REF: 23-02098-OUT

**Location: Begbroke Science Park, Begbroke Hill,
 Begbroke, OX5 1PF**

17 January 2024

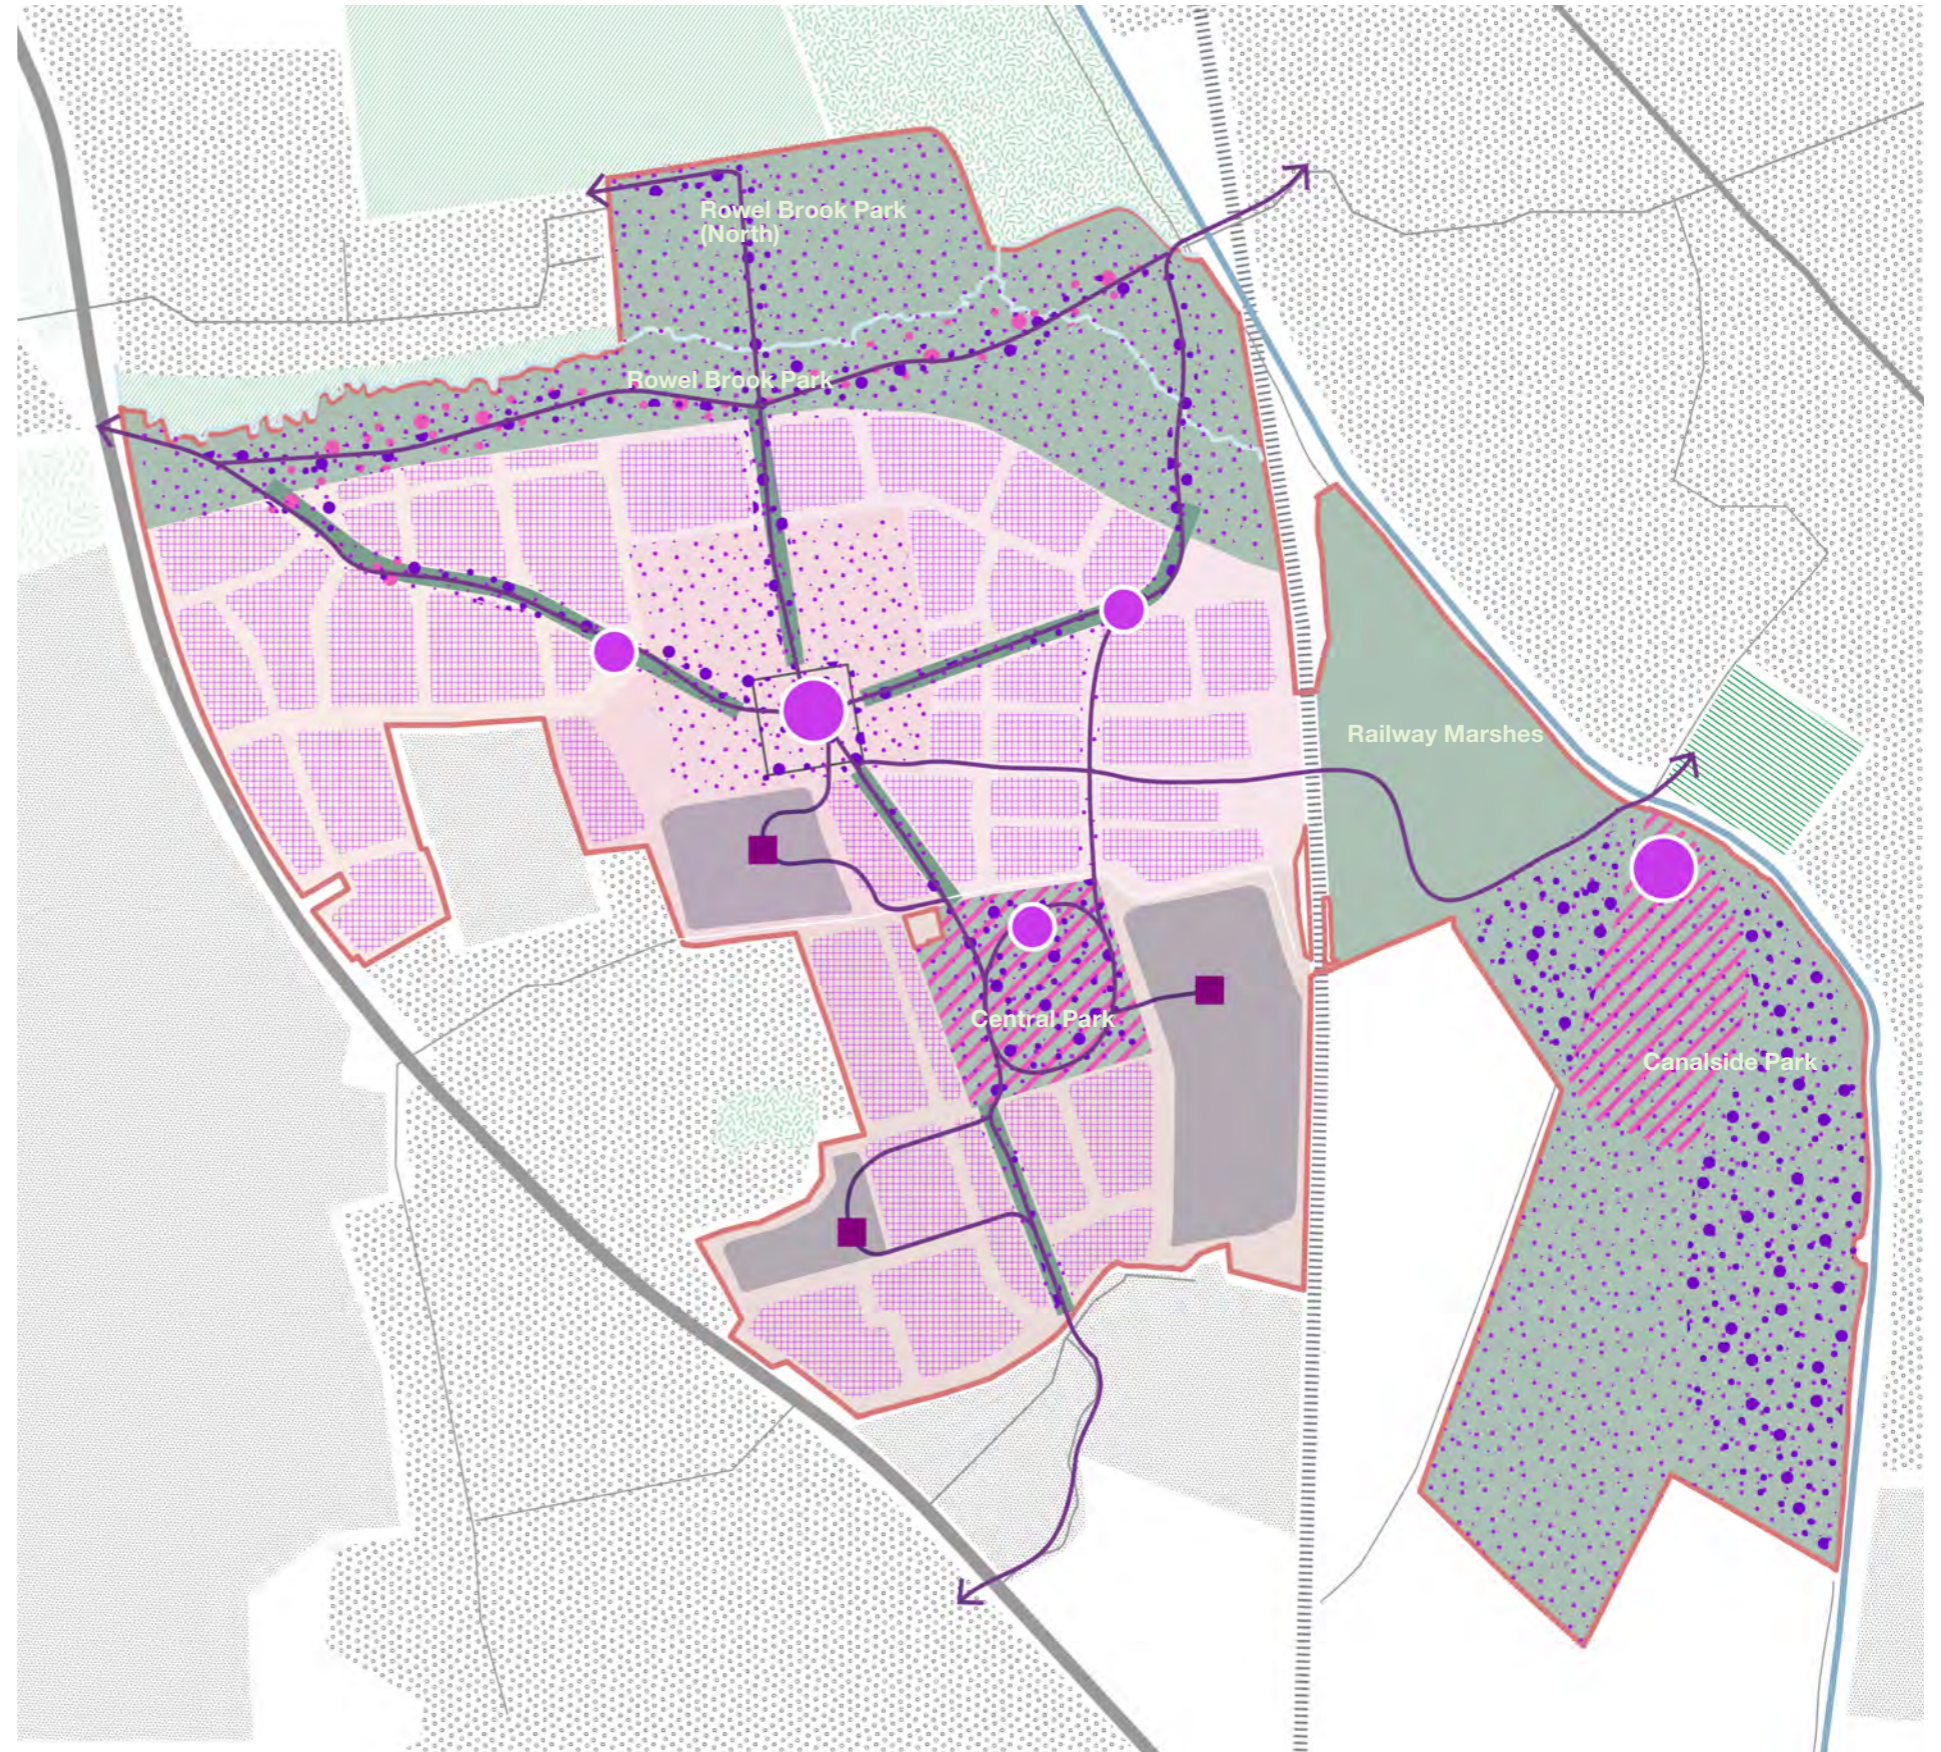
3.4	Play areas must be carefully located where they are well overlooked by surveillance from surrounding	Agreed. We suggest that principle 3.4.5 is amended as such:	Noted, however “Where practical” suggests this may not always be the case – as per my

development.	“Clearly defined equipped play area should be integrated within each neighbourhood <u>and should benefit from passive surveillance, where practical.</u> ”	comments this should always be the case to prevent crime and ASB within these facilities, as such I suggest removing “Where practical” from the design code.

4.1. The Arrival

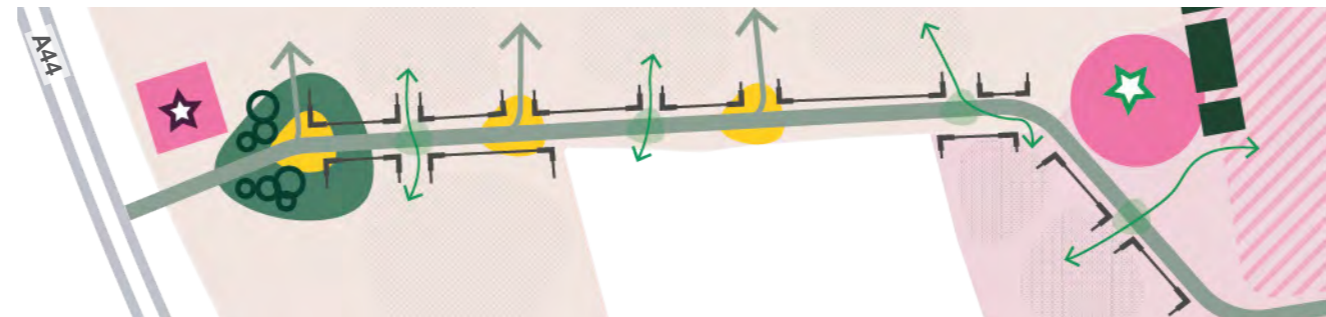
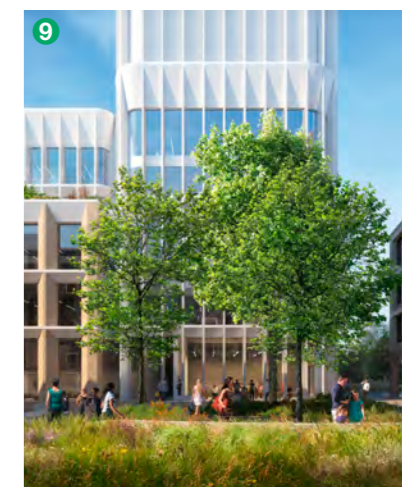
4.1	<p>The indicative arrival road layout will be very vulnerable to speed - I suggest an additional point is added or drawings amended to include a requirement for the road to be designed to the speed intended without the need for police enforcement.</p>	<p>Agreed. The following will be added:</p> <p>'The street should be designed to naturally encourage lower vehicle speeds.'</p>	<p>Noted and accept wording proposed.</p>

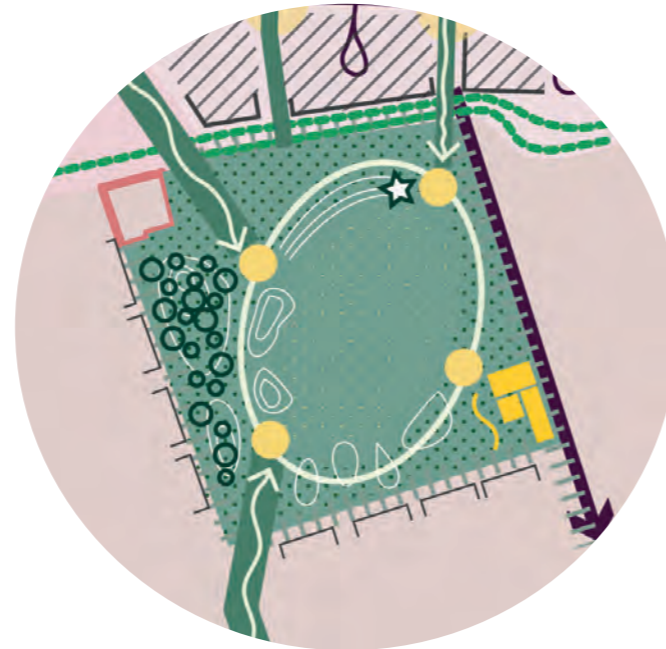
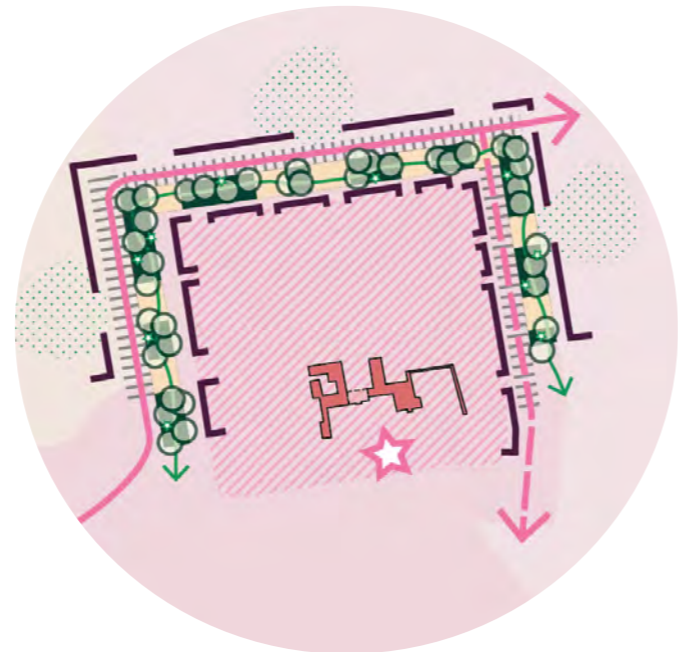
4.4	<p>I ask that an additional requirement is added that the park will be protected from unauthorised vehicular incursion.</p>	<p>Agreed. The following will be added:</p> <p>'Landscaping will be used to prevent unauthorised vehicular access into the Central Park.'</p>	<p>Noted and accept wording proposed.</p>

4.5. The interface

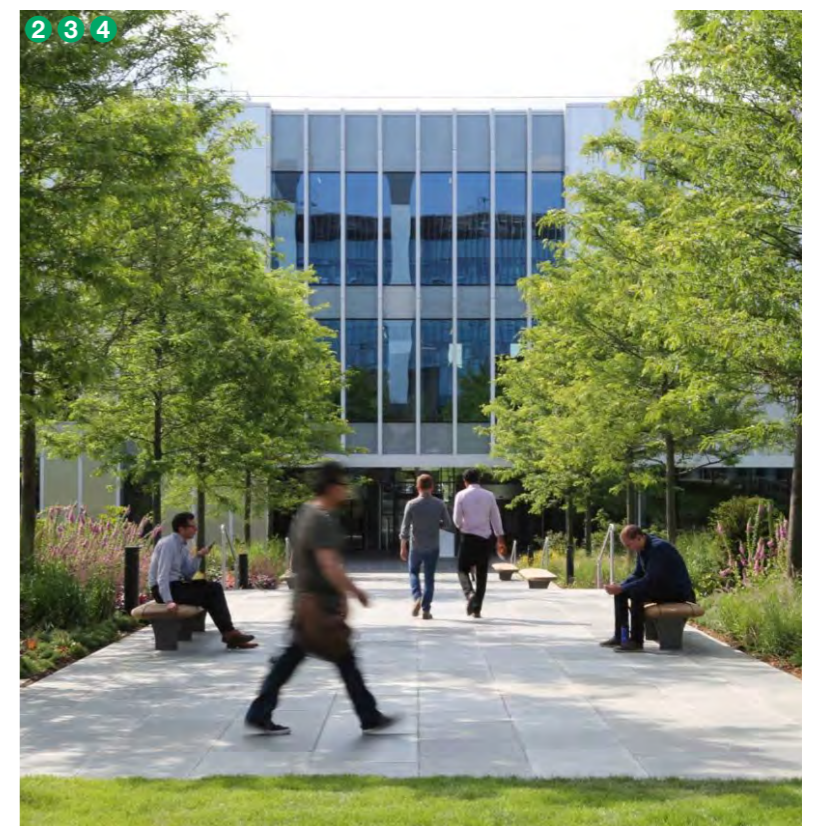
4.5	<p>Openings into the existing</p>	<p>Noted, we think this is</p>	<p>Noted.</p>

<p>science park should be added with great caution, to avoid undermining the security of existing development, particularly important to make sure any openings don't enter into vulnerable private space such as service yards or building boundaries where this little or no surveillance.</p>	<p>adequately covered by allowing openings to be created 'where appropriate'. More detailed proposals will be put forward and considered through Tier 2 and 3 submissions.</p>

4.6. Research and Development

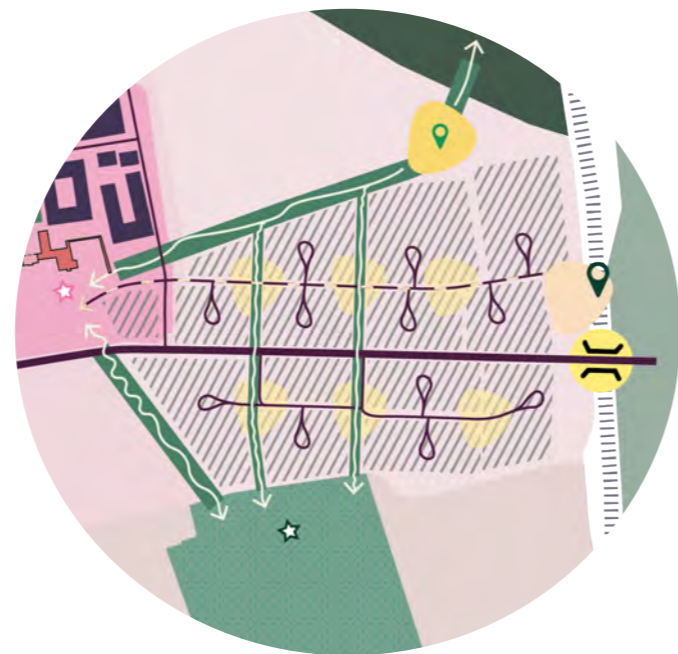
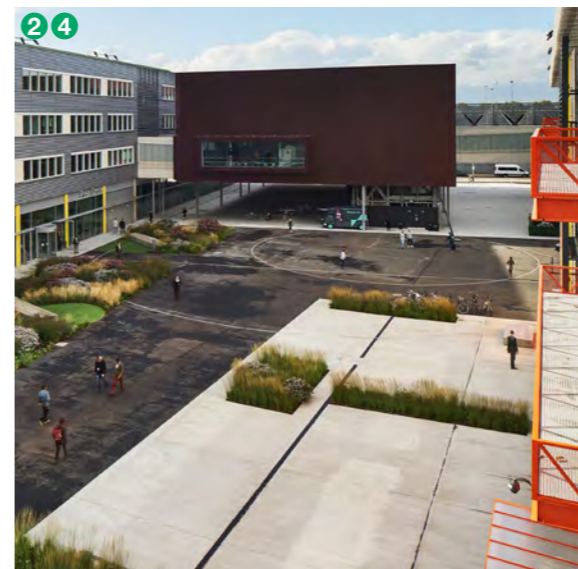
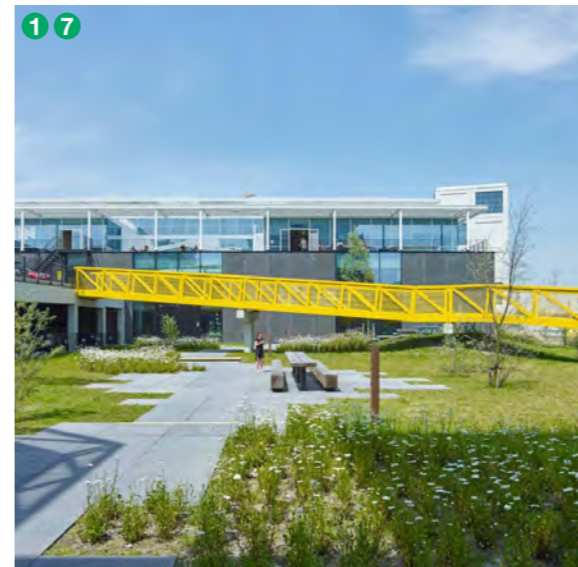
4.6 RD2	<p>Given the nature of development and possible uses of buildings, particularly for lab space, it may be inappropriate for buildings to be open and permeable/publicly accessible. This creates significant risk particularly where buildings may contain valuable or potentially dangerous holdings. I do not think this should be mandated as it may restrict the acceptable uses of buildings going forward, particularly if labs are proposed. Excessive permeability and a lack of secure lines makes the identification and apprehension of offenders far more difficult.</p>	<p>Noted and agreed. RD2 does not equate to a mandate as it only sets out that buildings 'should' be open and welcoming. If a particular building did need additional security, then this would not contravene the SDG. No updates are considered necessary, therefore.</p>	<p>Noted.</p>

4.6 RD3	<p>Again I have fundamental concerns that servicing areas may permit pedestrian access, as these areas are often the most vulnerable areas of a building with numerous routes of access into buildings whilst having limited surveillance. Excessive and open permeability around private commercial buildings makes it impossible for the tenants to identify or challenge the presence of an offender, creating significant vulnerability and opportunities for criminal activity and hostile reconnaissance.</p>	<p>Noted. This principle relates more to the servicing routes rather than the areas themselves. We will update the wording to make this clearer.</p>	<p>Noted.</p>

4.7. Green Arteries

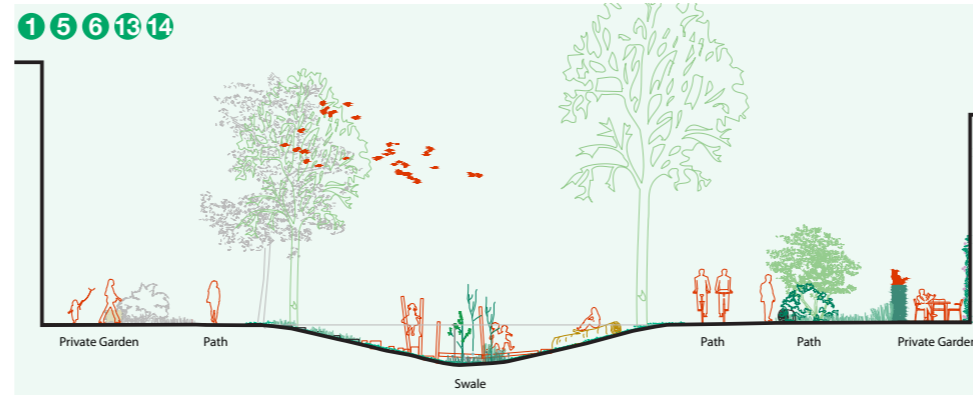
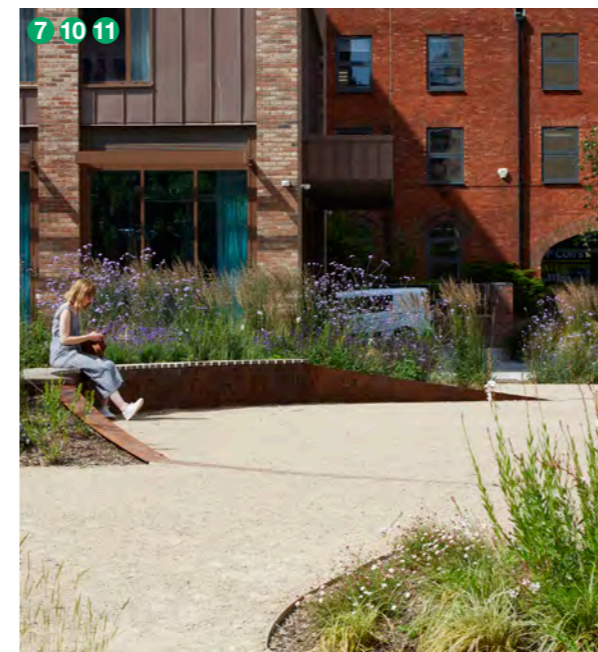
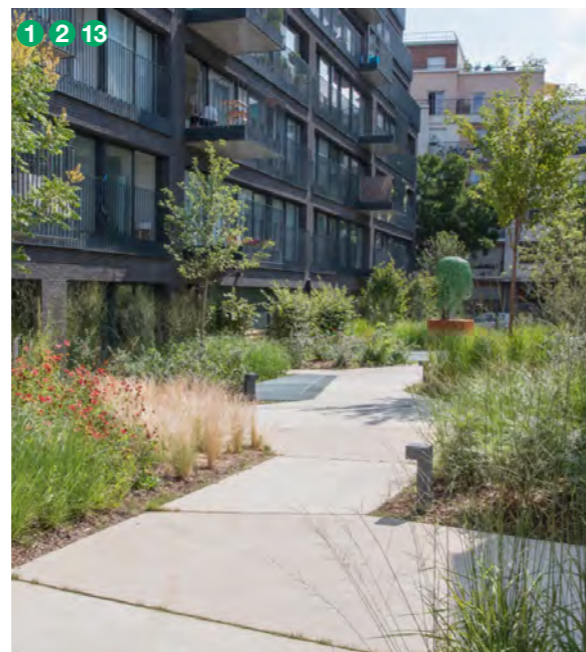
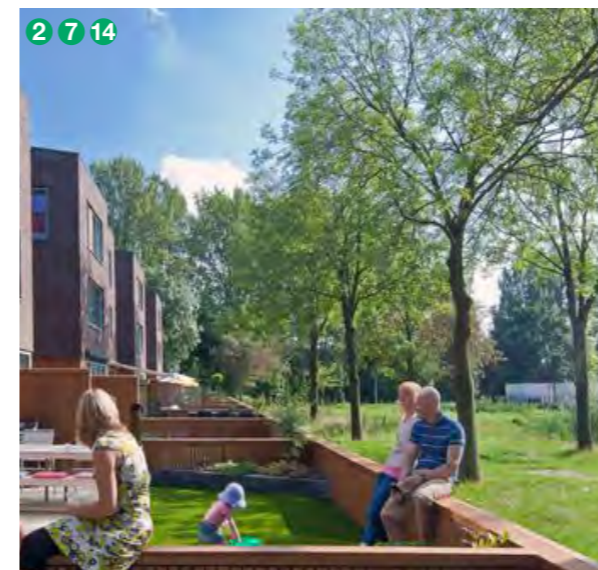
4.7 GA12	<p>I have concerns that excessive permeability may undermine the security of the development, creating opportunities for crime and ASB, and providing multiple routes of escape for offenders making apprehension almost impossible. If this</p>	<p>Noted. We have committed to updating section 3.8 to ensure that unauthorised vehicular access is suitably restricted. The incorporation of non-vehicular green arteries is however a fundamental part of the design vision, one that has been discussed at length with</p>	<p>I maintain concerns regarding permeability and the potential to increase crime and ASB within residential areas, and this proposal may hamper any emergency services response to these sites.</p>

development is left highly permeable, it may become a significant target for criminal activity.	the Council and independent Design Panel, both of which support the proposals.

4.8. Begbroke Hill Green Artery

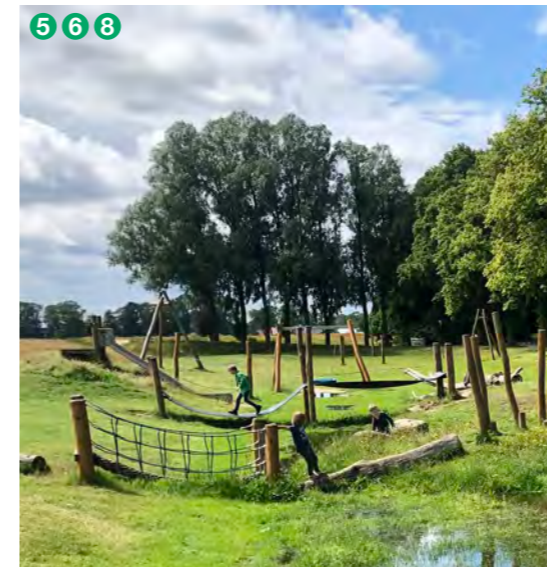
4.8	Illustration for points 1,4,5 (top right) - this image indicates private patio areas are open and directly accessible from the public realm, with no defensible space or standoff, which would not be acceptable.	This is just an illustrative image and does not necessarily set a precedent for future development. We are not proposing to update this image, however.	Noted, however I have concerns that illustrations of unacceptable design are included in an important control document.

4.11. Living Streets

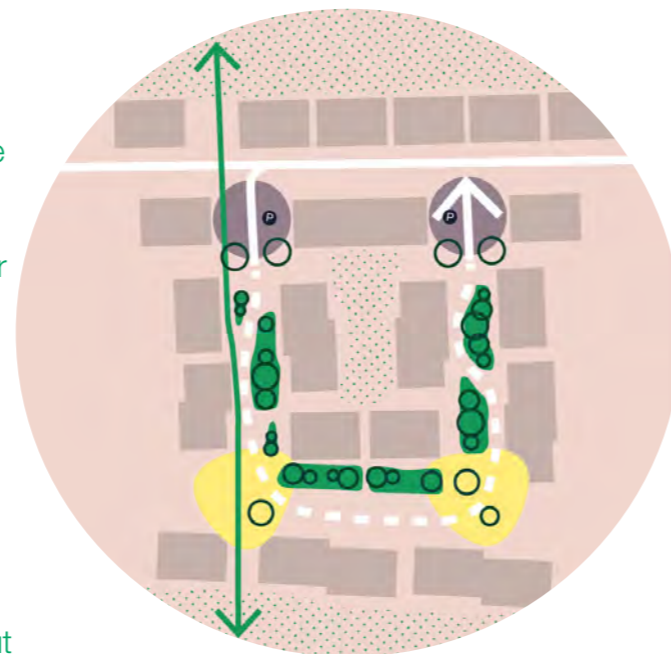
4.11	See above, I have fundamental concerns with the proposed parking strategy for this area of the site. Parking must be safe and secure, and must have high levels of surveillance and ownership from the dwellings it serves. Thinking about the government drive to reduce violence against women and girls, research shows that women feel and are most vulnerable to crime in the first and last section of their journey. Thinking of a lone female having to go from her car to her front door at night, the location and design of parking must ensure she feels safe.	Noted. The plan image is illustrative but indicates that the parking areas would be very well overlooked by residences. The scales involved are not large and it would be only a short distance from the parking area to the dwelling. More generally on parking, whilst we acknowledge and appreciate your comments, we also have to balance comments such as your against the County Council's Street Design Guide, which clearly sets a preference for ' <i>innovative parking solutions which keep as much parking within the public realm... or at least have the ability to become public realm as car ownership drops resulting in less spaces being required.</i> ' Our strategy does not place a blanket requirement for one type of parking over another, only a preference for consolidated parking areas to allow living streets to be delivered, in accordance with the County Council's guidance.	Noted. I hope I am given the opportunity to work with the design team at the earliest pre-application stage to ensure secure parking areas for this development.

4.11	No guidance is given as to how the design and layout of this area will prevent unauthorised or inappropriate parking.	This is a level of detail that we consider is more appropriate to Tier 2 and 3 submissions.	Noted.

4.11	Benches within private residential streets must be carefully considered, otherwise may be attractive to loitering and ASB particularly if they are lit in the evenings and at night.	Noted.
